Recommendation Report for Planning Permission for Works or Extension to a Dwelling

REF NO: BN/10/21/HH

LOCATION: 2 Park Cottages
Goodacres
Barnham
PO22 0JE

PROPOSAL: Loft conversion consisting of hip-to-gable roof extension and rear box dormer with roof windows to front elevation.

Drawing
Proposed Elevations

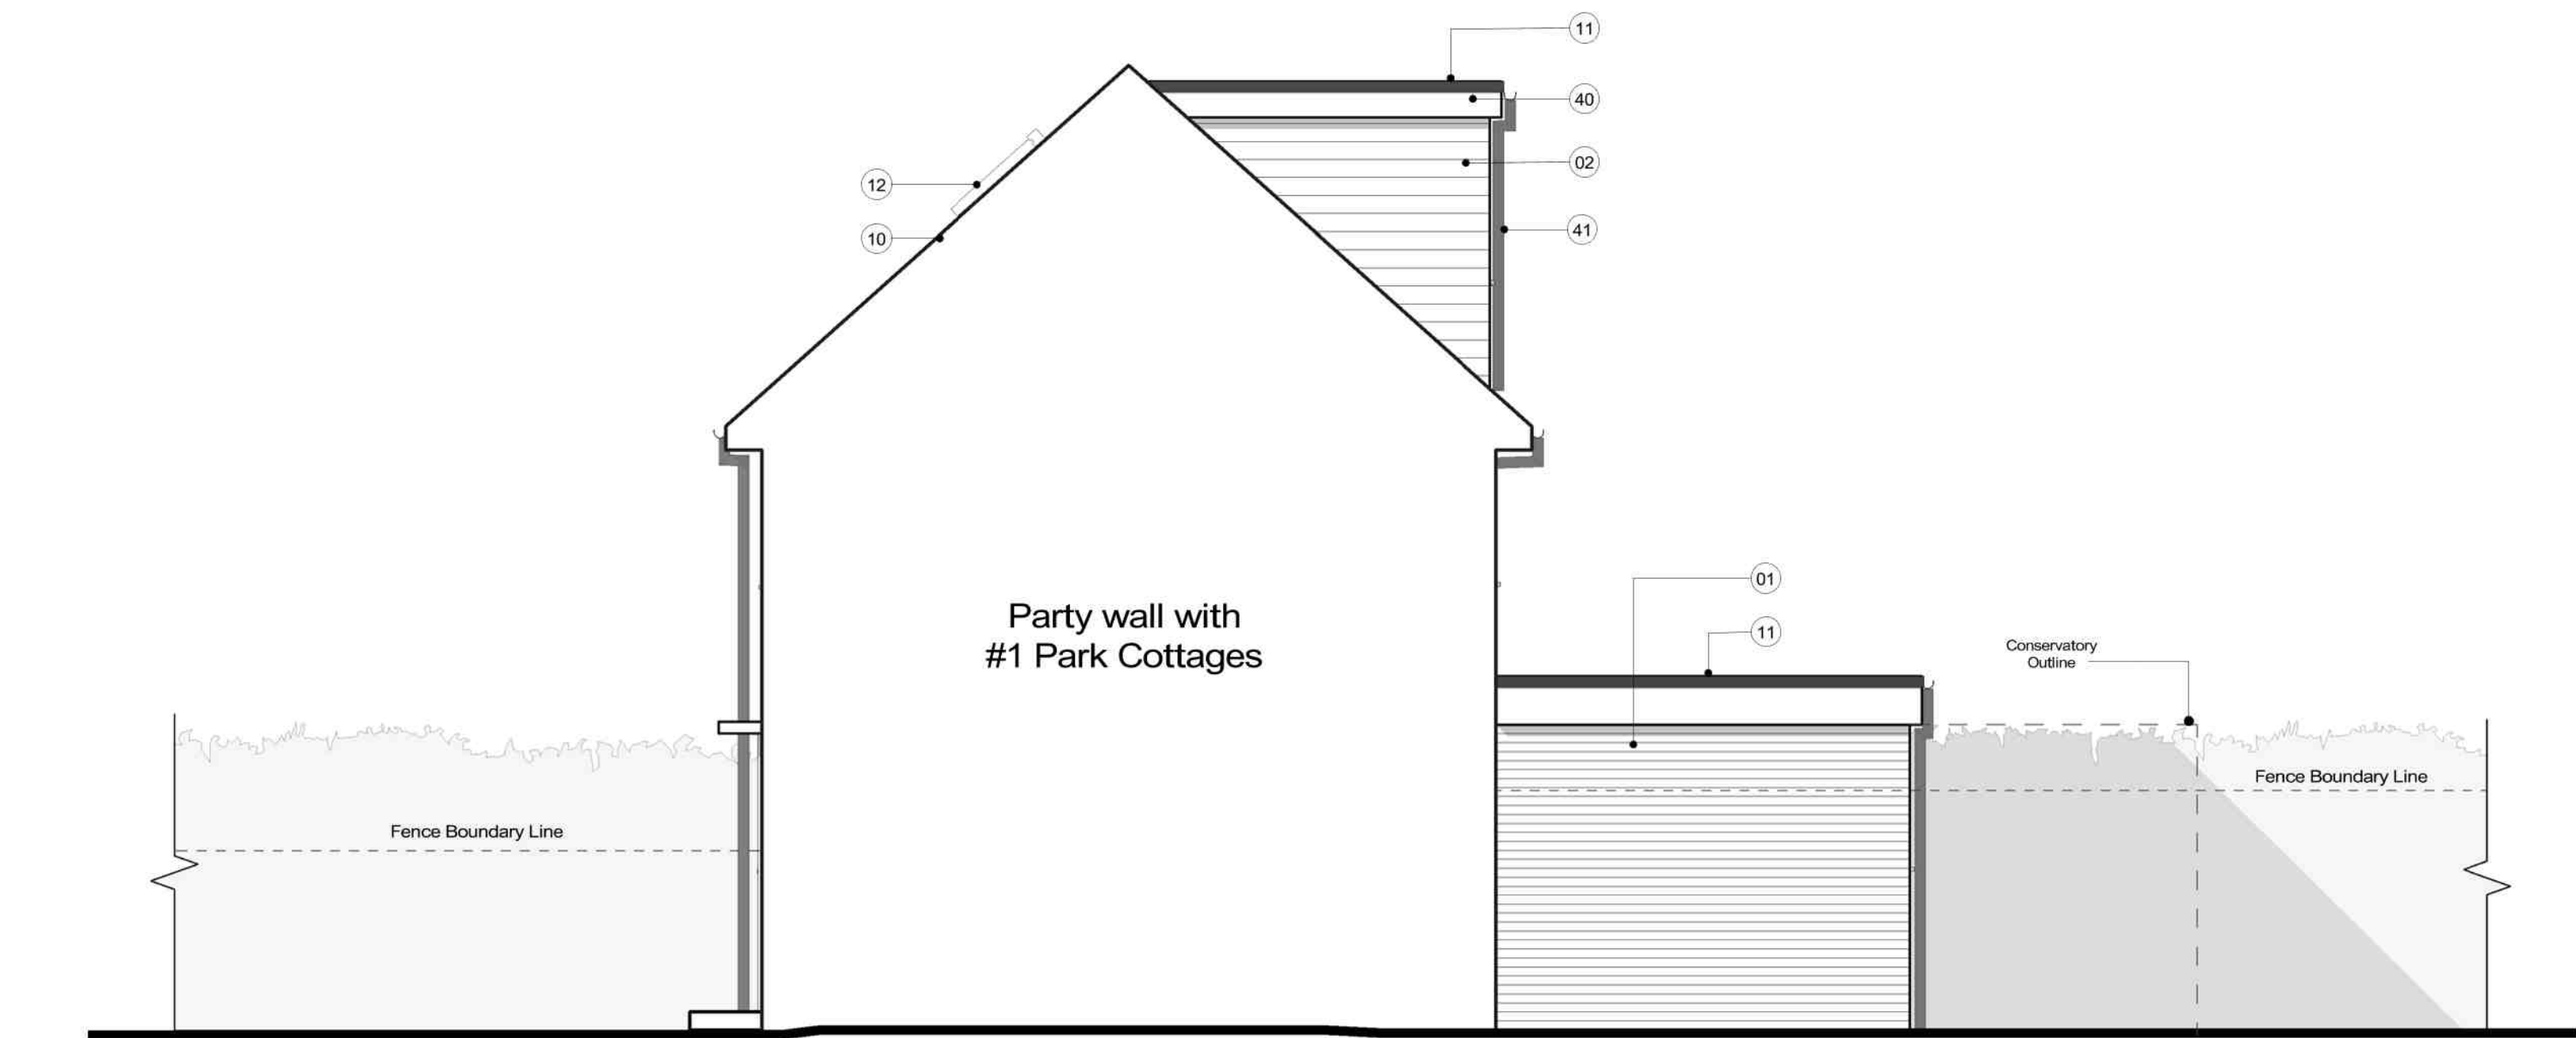
The hip to gable extension will be visible from the street and will have the effect of unbalancing the pair of semi-detached properties, however it is noted that this could be constructed under the properties Permitted Development rights and its impact could be felt even on refusal of this application. There is a varied mix of housing types and styles along the road, both single storey and double with differing roof types and an eclectic mix of materials therefore the creation of the gable end is on balance, not seen as a strong enough reason for refusal.

In terms of overlooking, the fenestration is predominately directed towards the rear of the property, overlooking the rear except for one window to the Eastern elevation which serves a bathroom. The side facing window has been designed to be obscure glazed and fixed shut except for a top opening fanlight. In the interests of retaining privacy for the neighbours to the East, a condition shall be placed on the window to remain as approved in perpetuity. Comments in respect of overlooking have been carefully considered; due to existing windows at first floor level it is not felt that the fenestration to the 2nd floor will greatly increase the obtainable views it is felt no new views other than those already obtainable will be afforded to the proposed development in accordance with policy.

In terms of overbearing it is acknowledged that the hip to gable extension will affect the neighbouring properties, especially the bungalow to the East. However, the footprint of the host dwelling will not encroach any further towards the bungalow; maintaining a 3.7m gap to the shared boundary and over a 6m gap between dwellings which is felt is sufficient. As mentioned above it is believed that this alteration could be achieved without planning permission and therefore it is considered that any harm arising from the development will be minimal.

- Proposed floor plans 2002 01
 - Proposed elevations 2003 01
 - Proposed Block Plan 1001
Reason: For the avoidance of doubt and in the interests of amenity and the environment in accordance with policy DDM1 and DDM4 of the Arun Local Plan.
- 3 The proposed window at 2nd floor level on the Eastern Elevation of the building shall at all times be glazed with obscured glass and fixed to be permanently non-opening below 1.7m from FFL.
